REF: N147950

DATE: 27 February 2020

**RE: MEADOWBANK EDUCATION AND EMPLOYMENT PRECINCT SCHOOLS PROJECT – SSD
18_9343 RESPONSE TO TRANSPORT RELATED SUBMISSIONS**

Response to Submissions

B. BUS SWEPT PATH ASSESSMENT

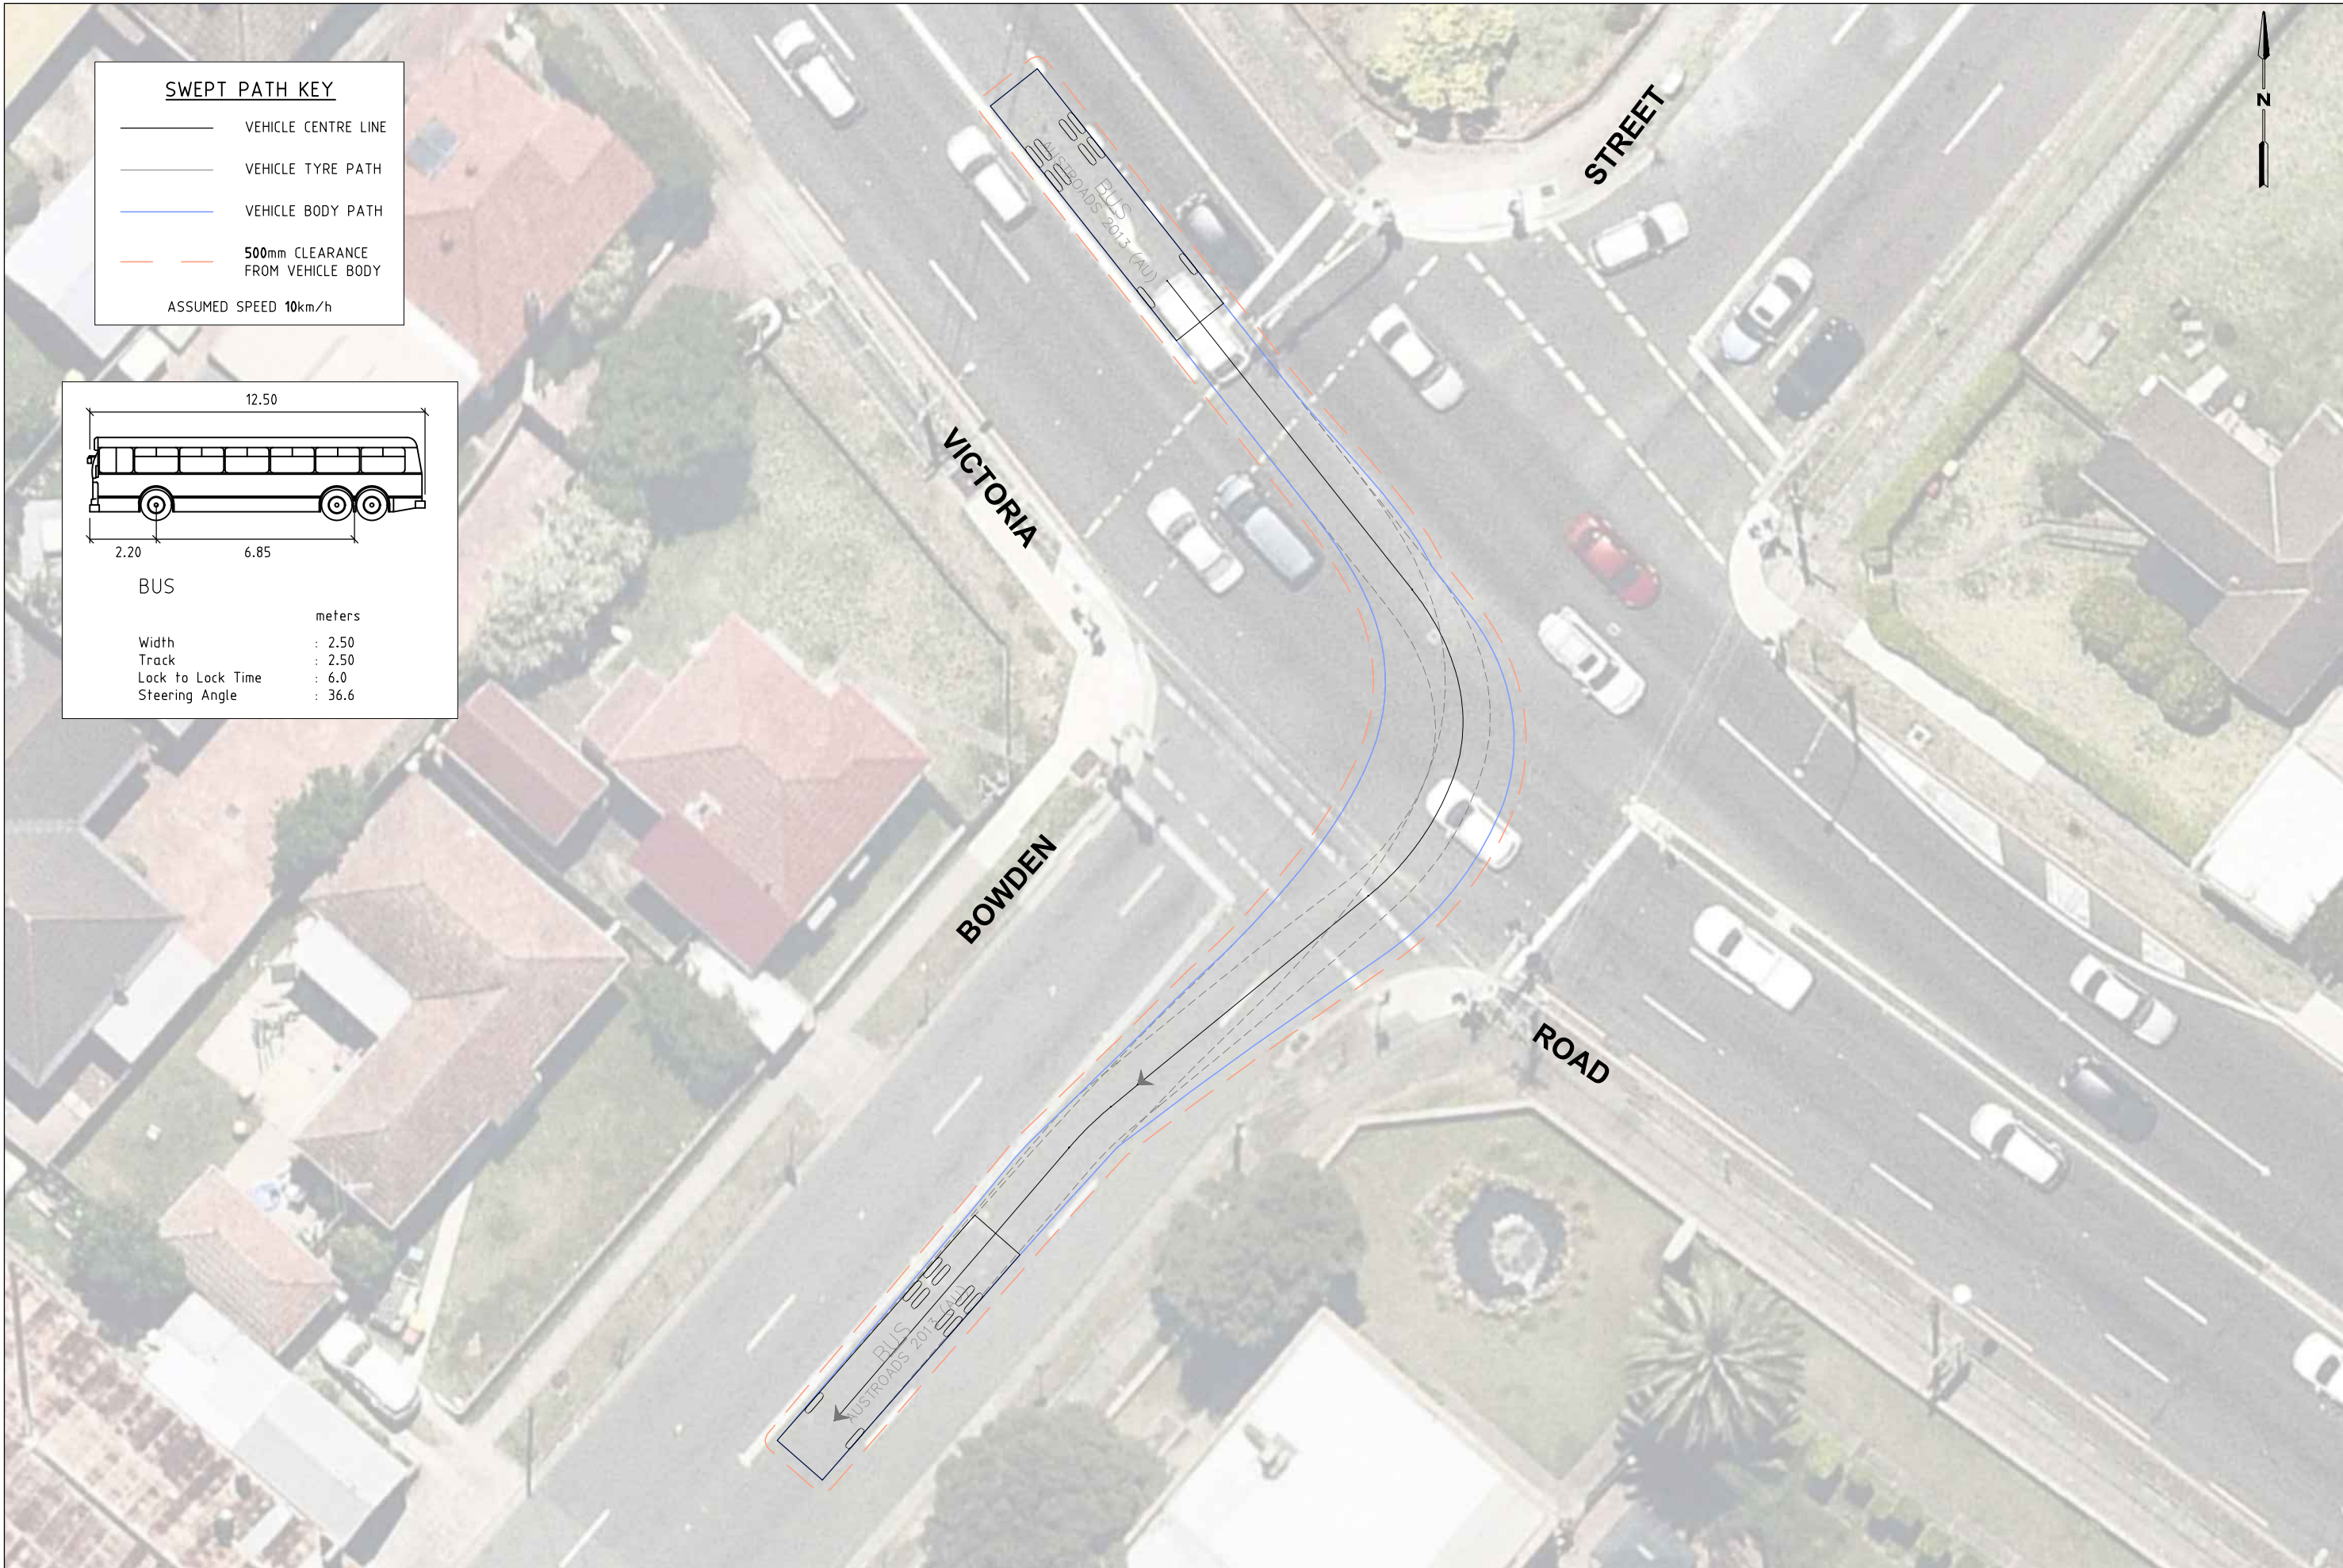
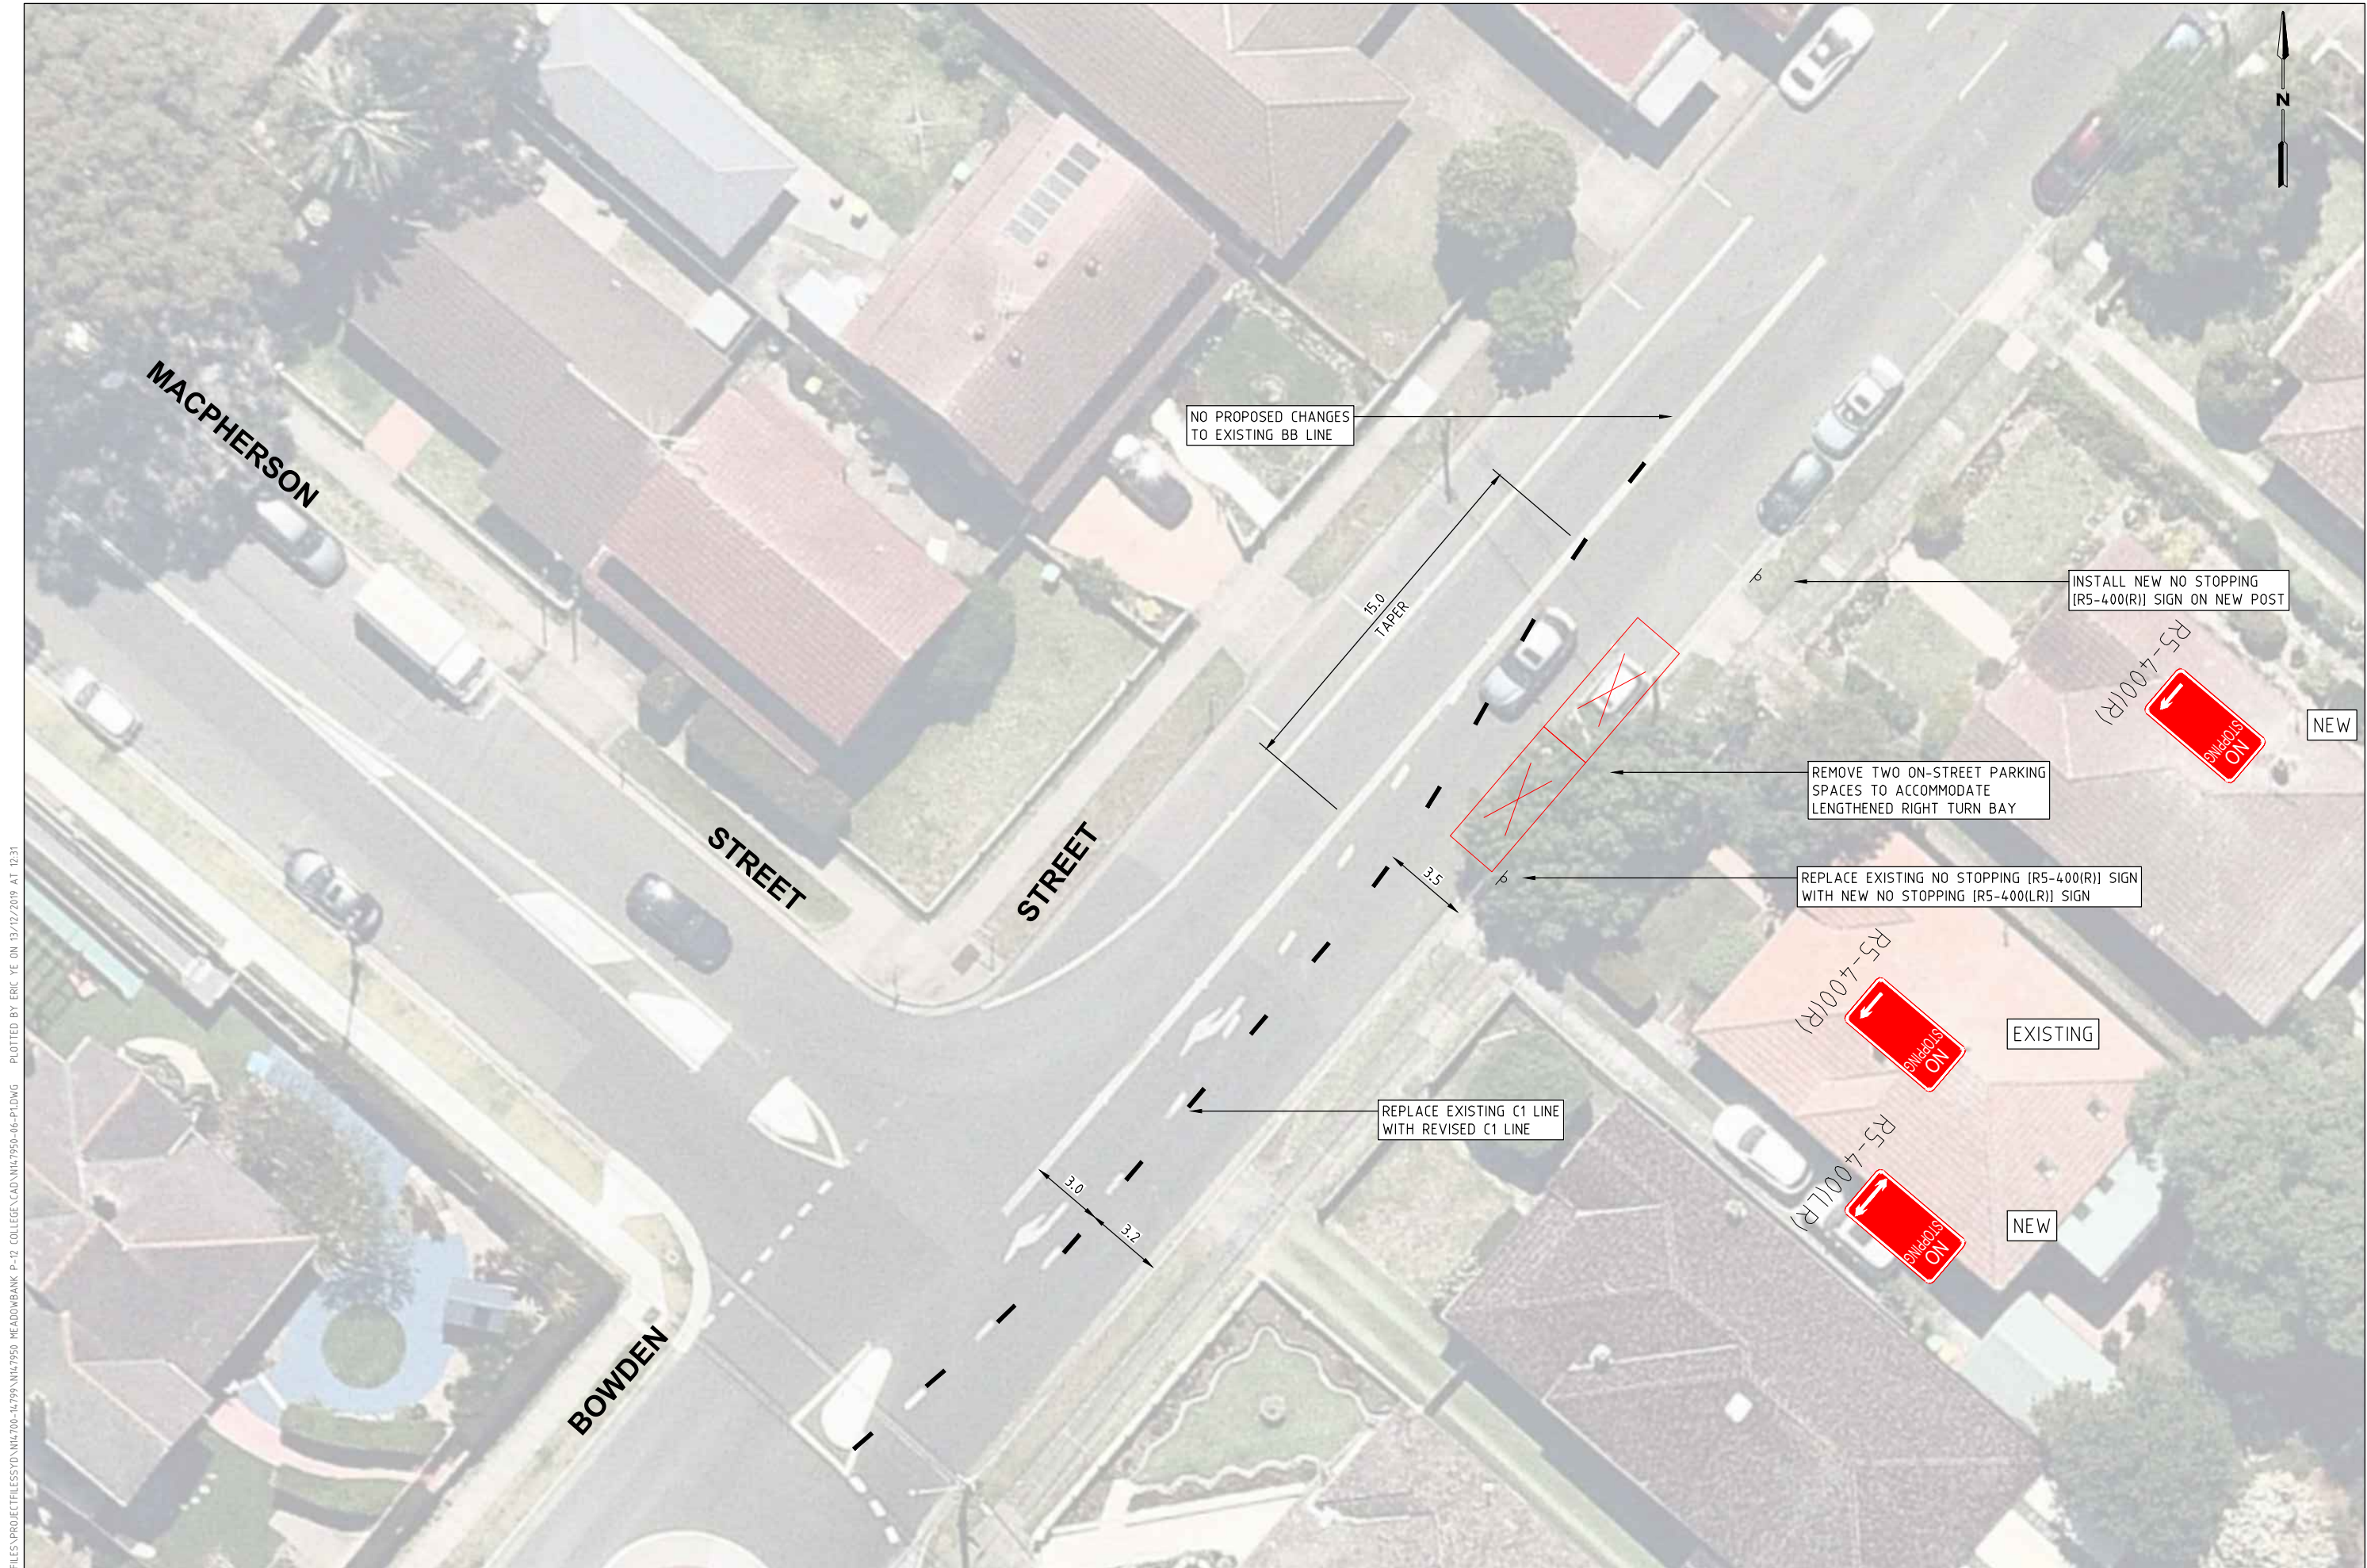
Comment 1: Swept path analysis should be provided for buses on all streets between Victoria Road and the proposed bus zone locations to ensure the surrounding streets are capable of accommodating the future school bus services. Turnaround facility on Rhodes Street with access for all services via Hermitage Road should also be considered to better facilitate the future traffic generating from the school sites. The proposed length and allocation to Primary school of a bus zone on Rhodes Street should also be further reviewed for servicing the proposed two school bus stops. Clarification should also be provided on how the works will be delivered.

GTA response: A swept path assessment has been completed for the likely 12.5 metre bus on approach and departure between the site and Victoria Road and shown in Attachment 2. It is noted that the proposed bus route (particularly Rhodes Street and Hermitage Road) is already a heavy vehicle access route for the existing industrial area.
